**KIRKLEES METROPOLITAN COUNCIL
INVESTMENT & REGENERATION SERVICE**

Reference No:	2023/62/92608/W
Site Address:	Carr Lea House, 56, Rawthorpe Lane, Dalton, Huddersfield, HD5 9NU
Description:	Change of use from one dwelling to two dwellings
Recommending Officer:	William Simcock

DECISION – Conditional Full Permission

Officer Report – 2023/92608

CLIENT	MRS R HARJI
DRAWING STATUS: PLANNING PERMISSION	
PROJECT	PROPOSED & EXISTING FLOOR PLANS 56, RAWTHORPE LANE HUDDERSFIELD HD5 9NU
TITLE	CHANGE OF ONE DWELLING TO TWO DWELLINGS

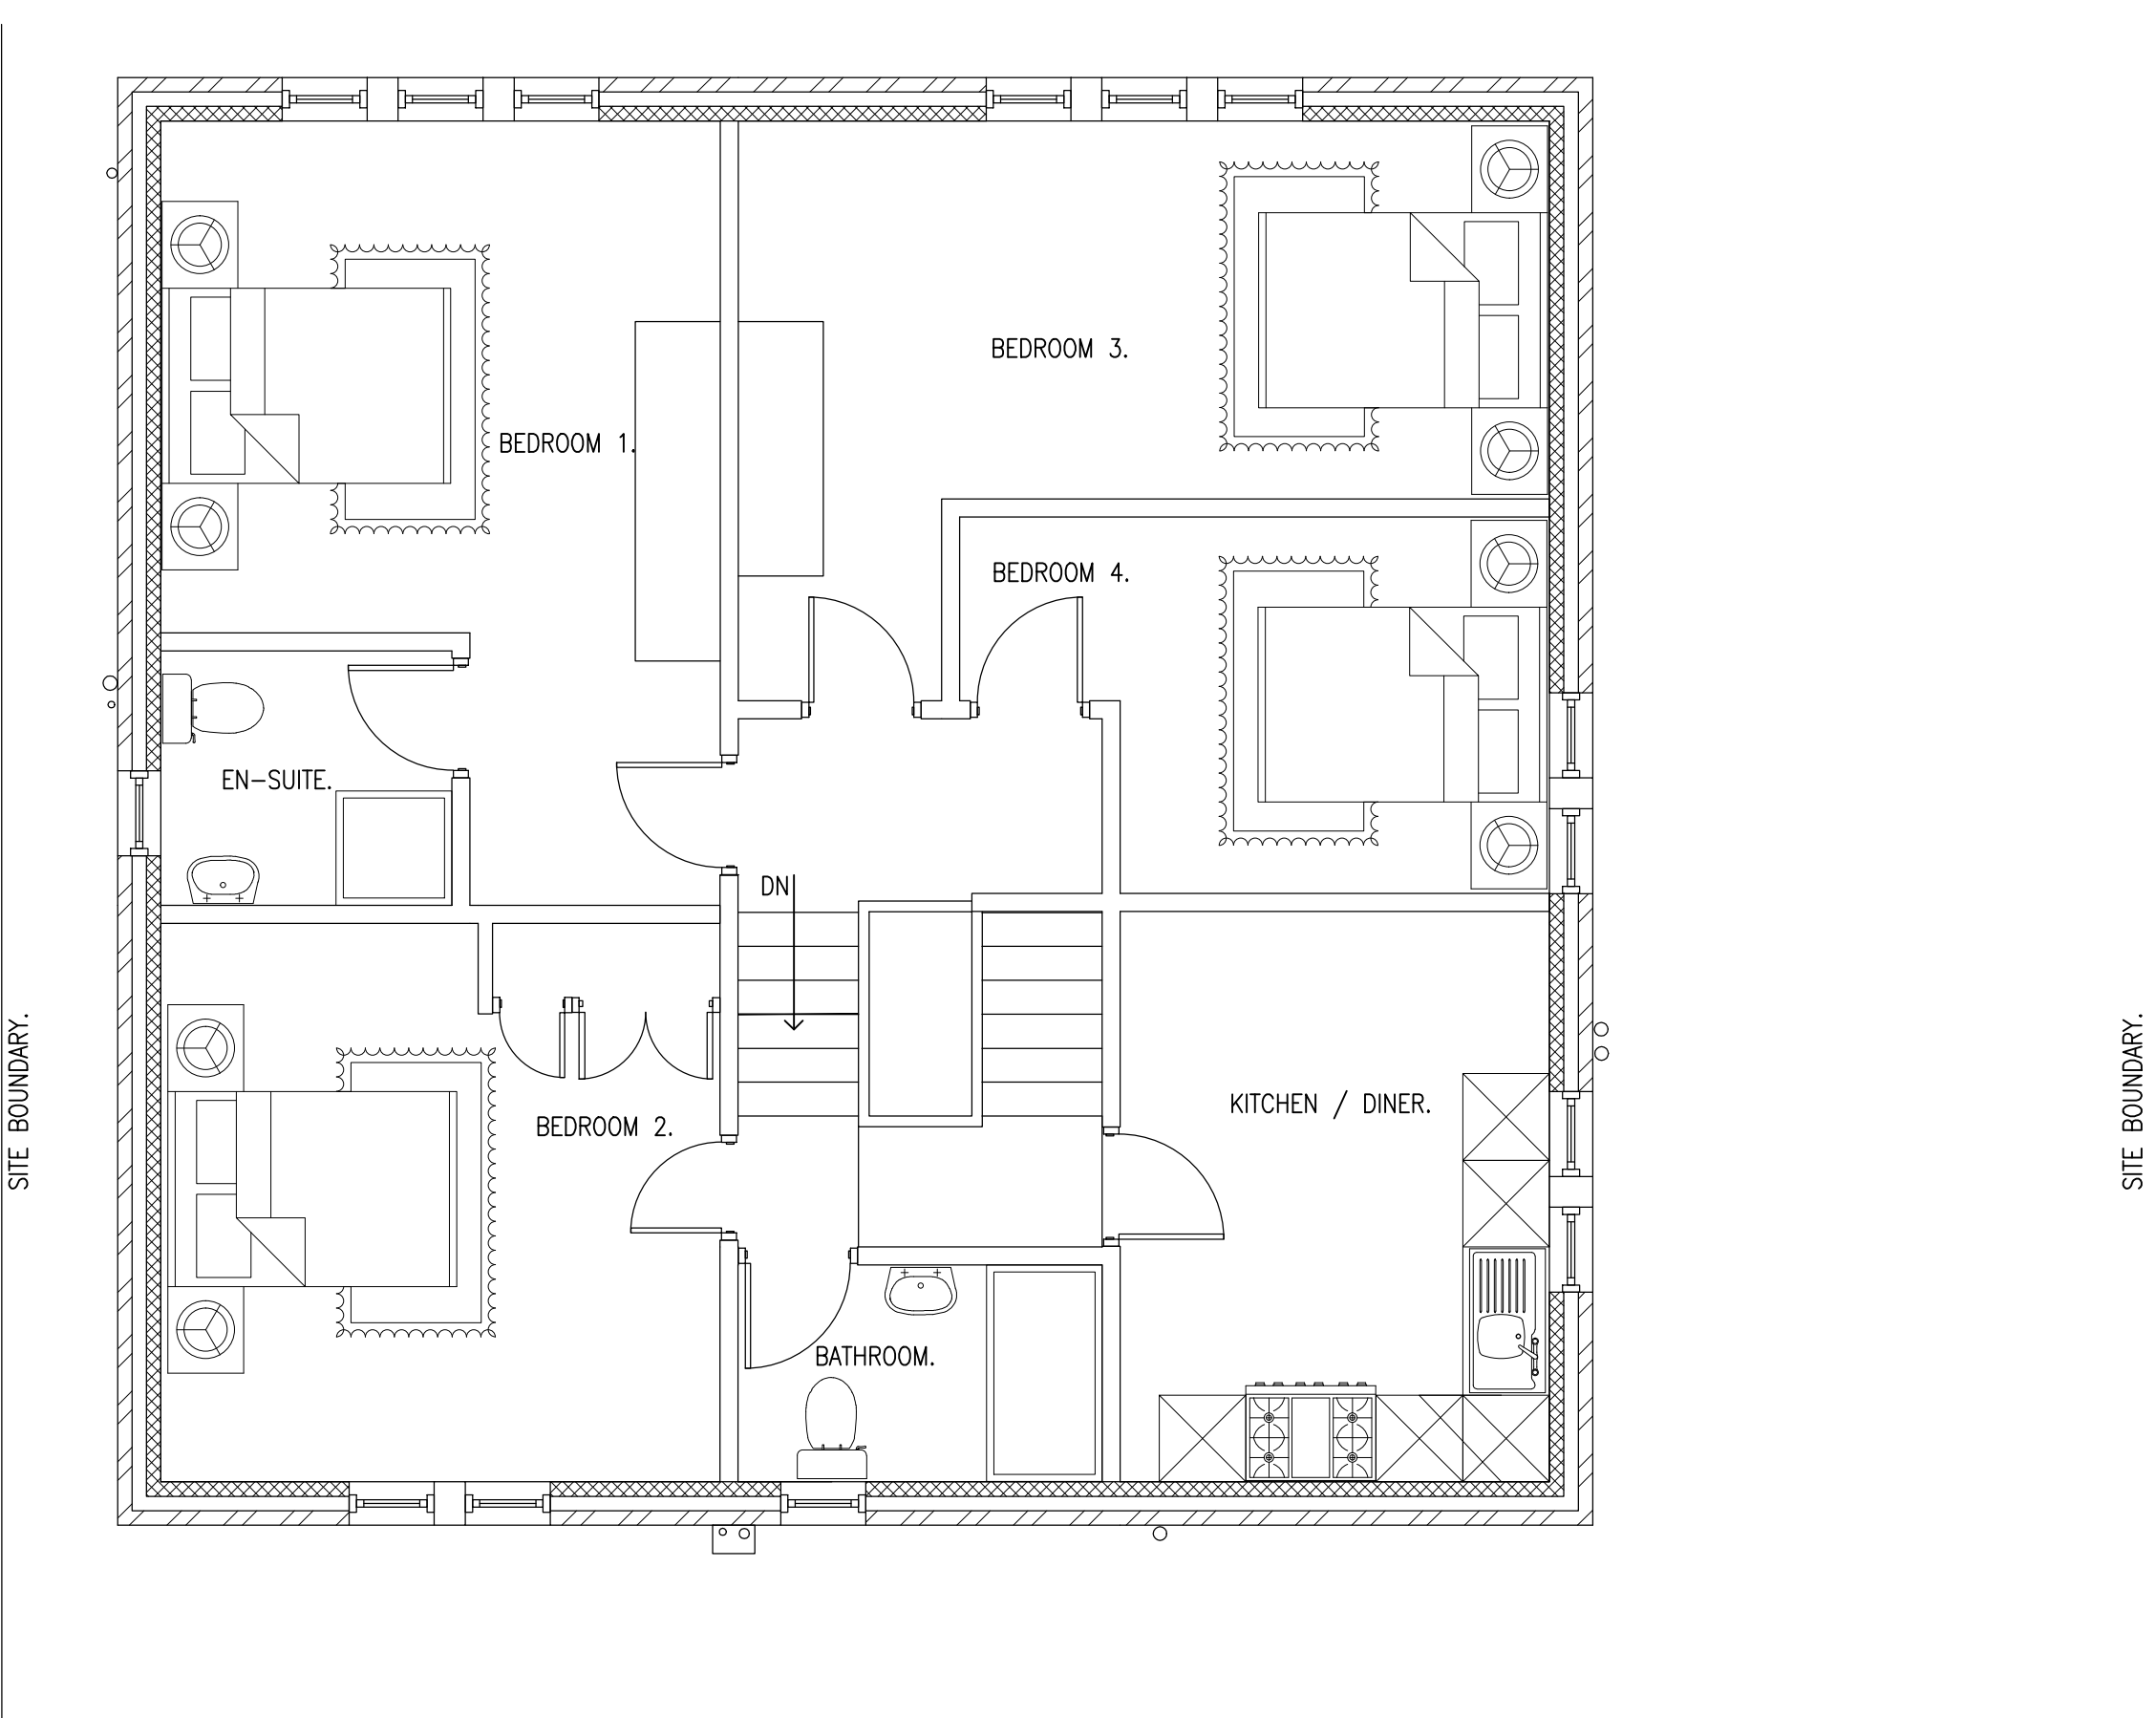
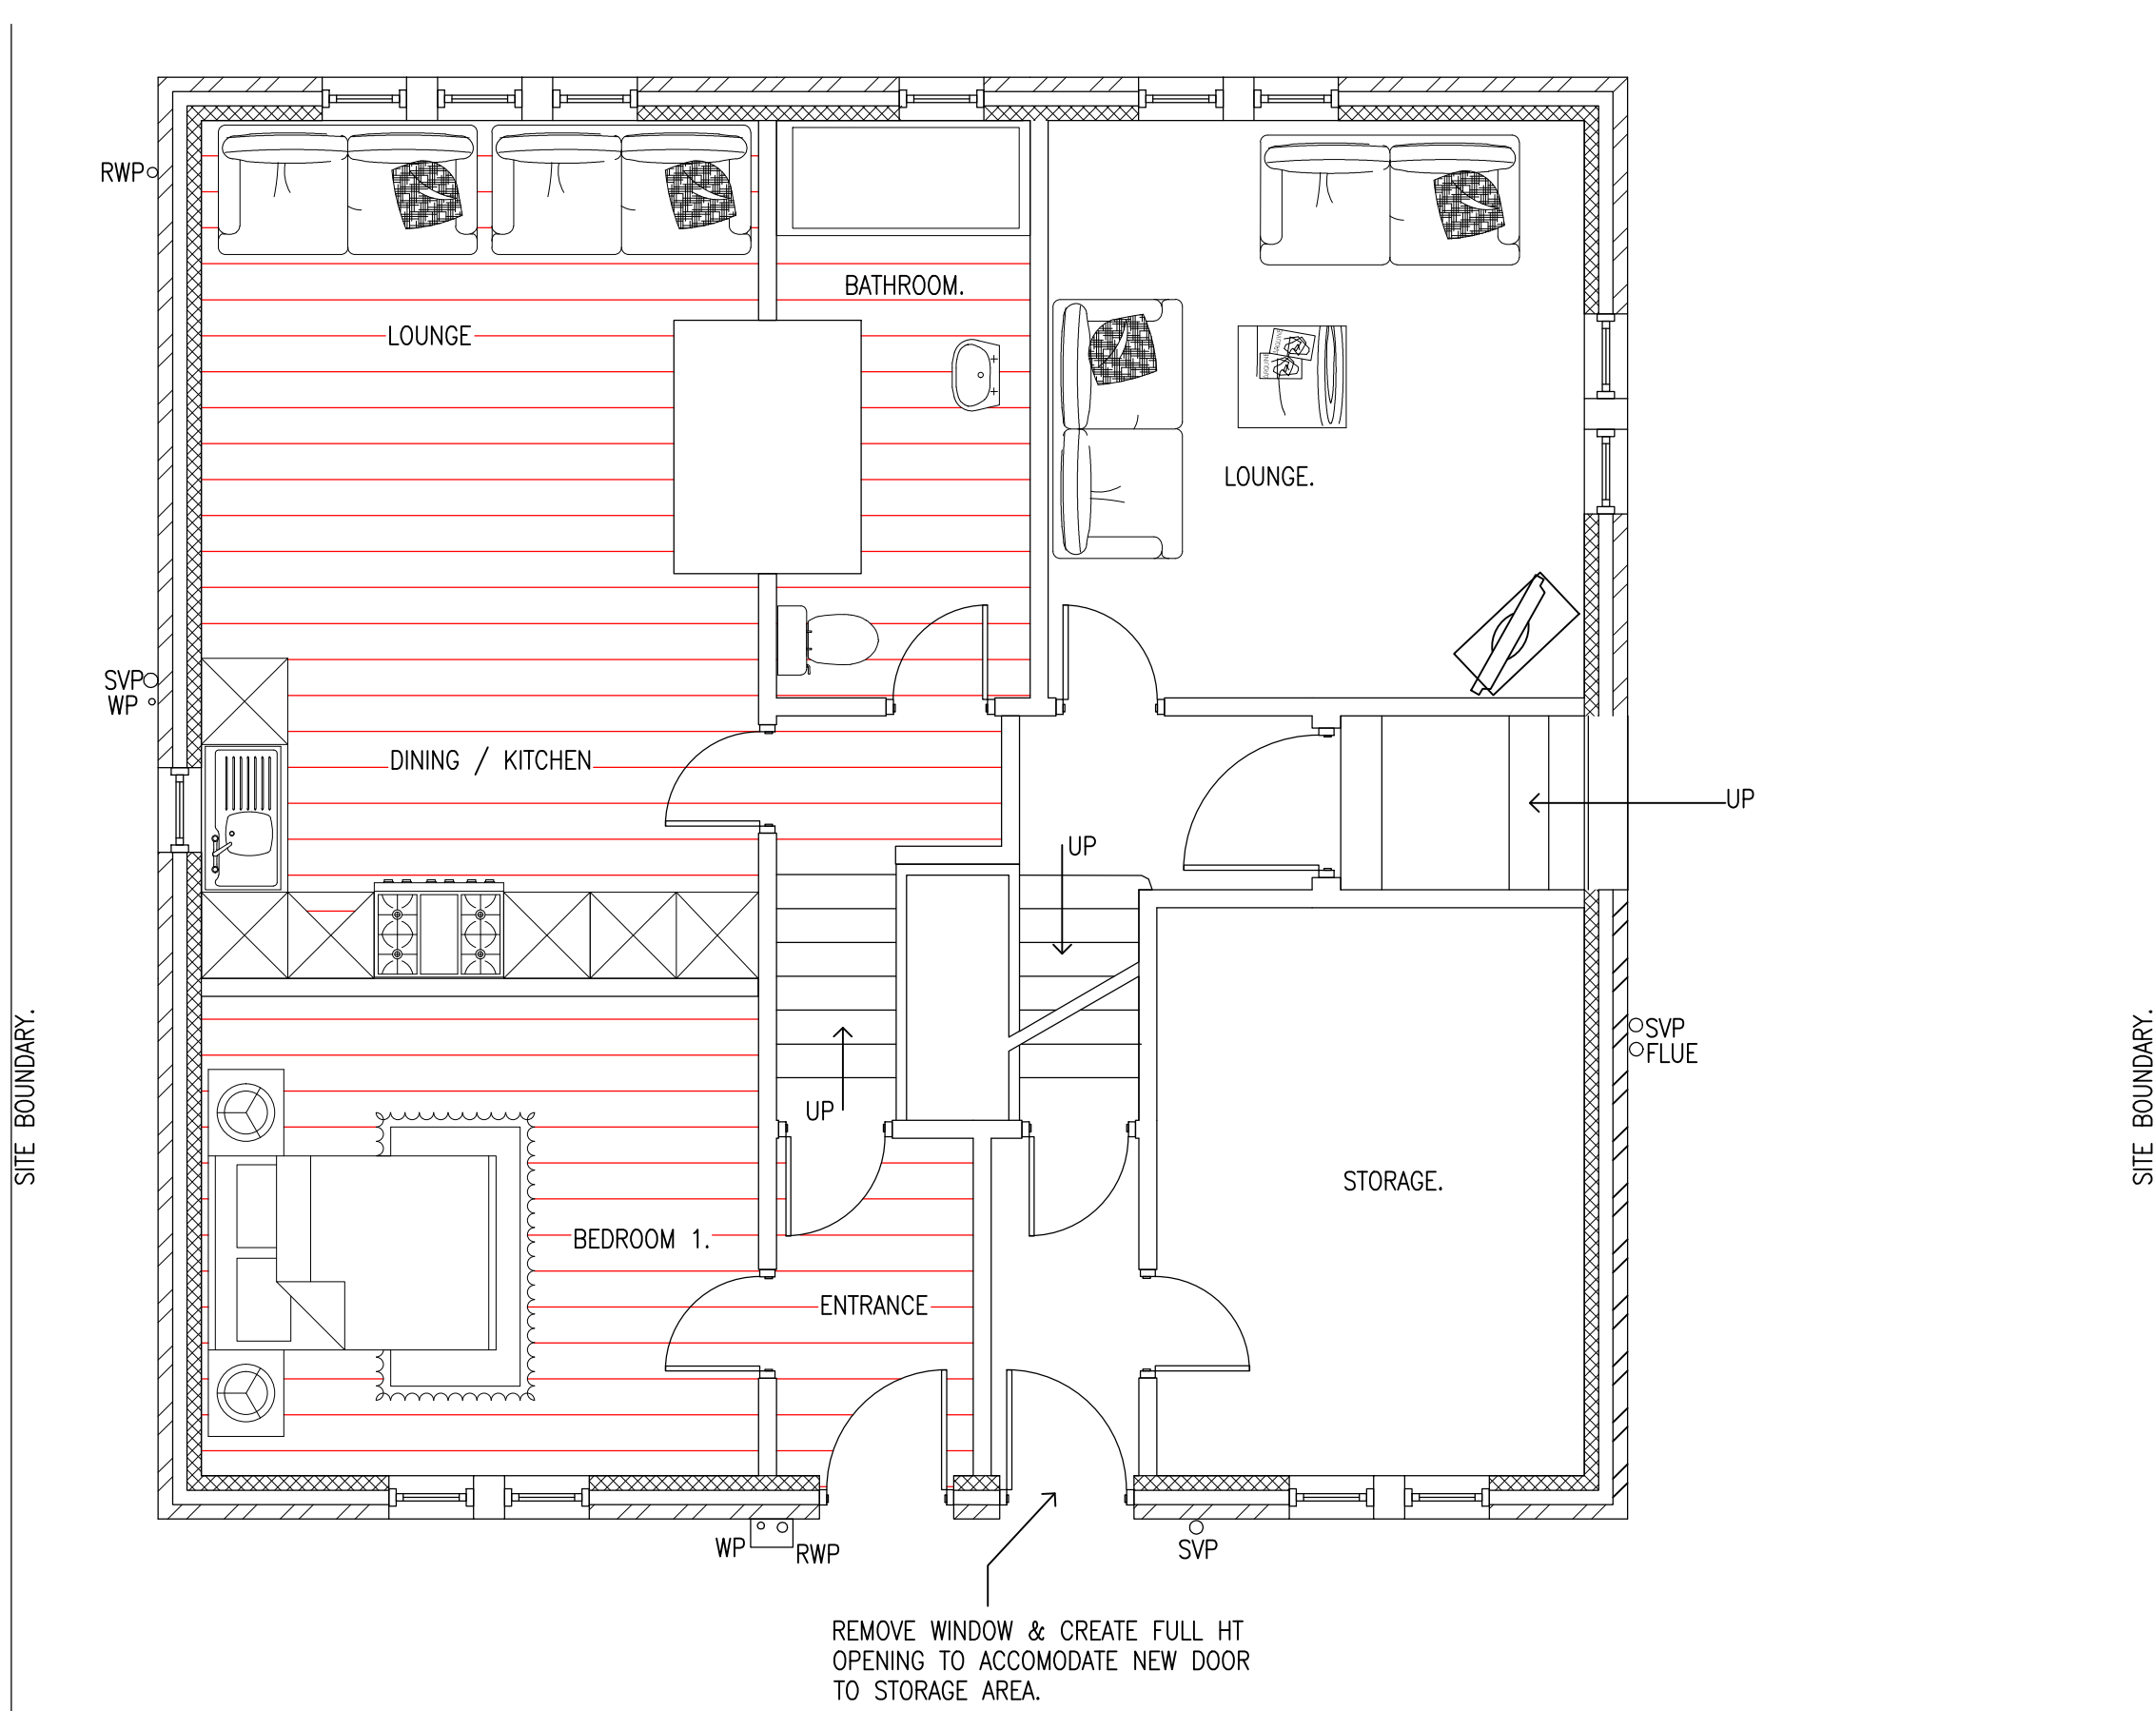
- A single-storey, single-bedroom dwelling occupying roughly half the ground floor, area 50sqm;
- A two-storey dwelling comprising a living room at ground floor rear, four bedrooms and a dining kitchen above, of approximately 104sqm floorspace.

A new entrance door would be installed in the front elevation to allow access to the storage room. The existing front and side doors would become the entrance doors to the two new dwellings.

Floor space for each dwelling would be in excess of the minimum required by the NDSS. It is considered that all habitable room windows in the two-storey dwelling would have an adequate outlook and receive acceptable amounts of natural light.
